Your ref: MP 08_0116 MOD 1

**RE: Environmental Assessment for the Modification to Potts Hill – Stage 2 Project
Application (MP 08_0116 Mod 1)**

Date: 7 July 2011

Fig.4 Magnetic field profiles calculated at 1m height above ground across the existing and proposed new sections of 132kV feeder in Cooper Road in East-west direction through the middle of property No:25.

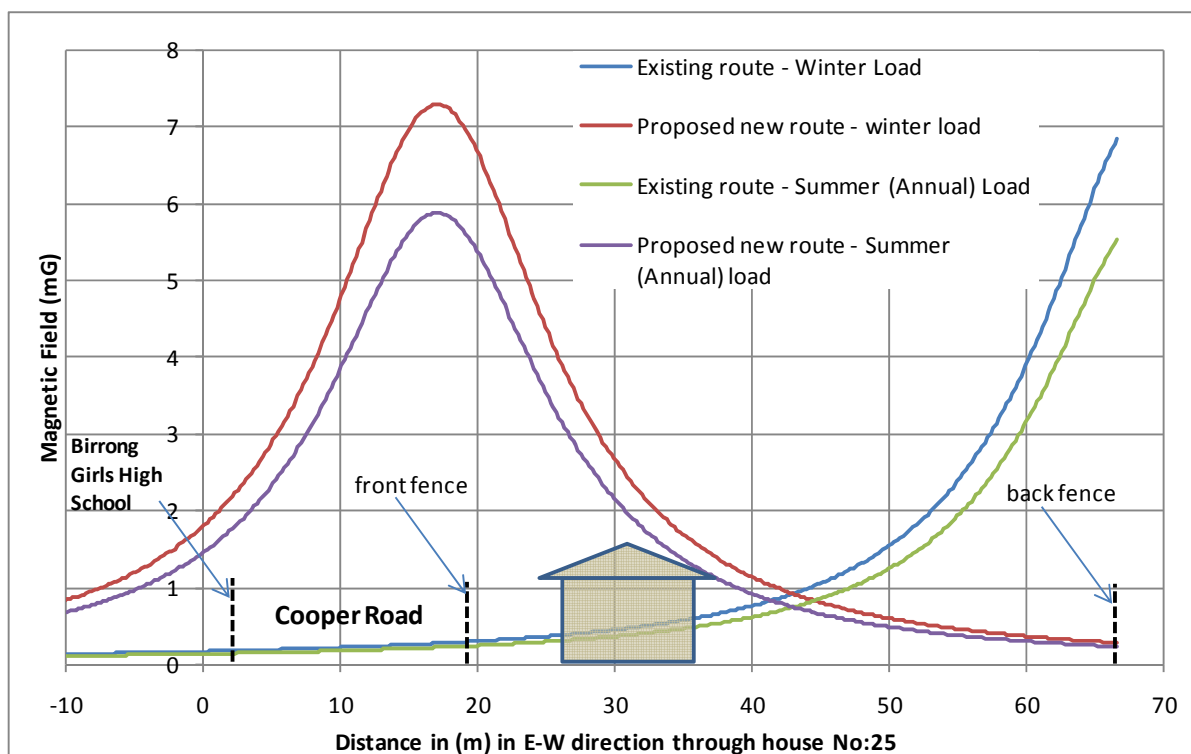
For the Project - *Proposed Relocation of Small Section of 132 KV Power Line in Cooper Road, Birrong NSW*, the following report entitled *Computer Modelling and Calculation of Magnetic Field Emission from Existing and relocated Feeders* was prepared by Magshield Products (Aust.) International dated 4 March 2011. This report provides a detailed assessment of EMFs exposures likely to occur as a result of the project. The Public Health Unit notes an increase in magnetic field emissions to the affected properties. This increase is predicted to go from 0.2-0.3 mG measured at 5m from the front boundary, to between 4.4-5.6 mG. This is a significant increase to the existing exposure. Both the NSW Government and NSW Health advocate a policy of prudent avoidance and this policy has not been demonstrated in this current proposal.

In summary, the EA predicts that sensitive residential receptors will be exposed to a substantial increase in EMF exposure above currently existing levels if the relocation goes ahead as currently designed. It is recommended that the design of the project incorporate all reasonable and feasible measures with the objective of reducing this predicted increase over background levels or that the relocation is reconsidered.
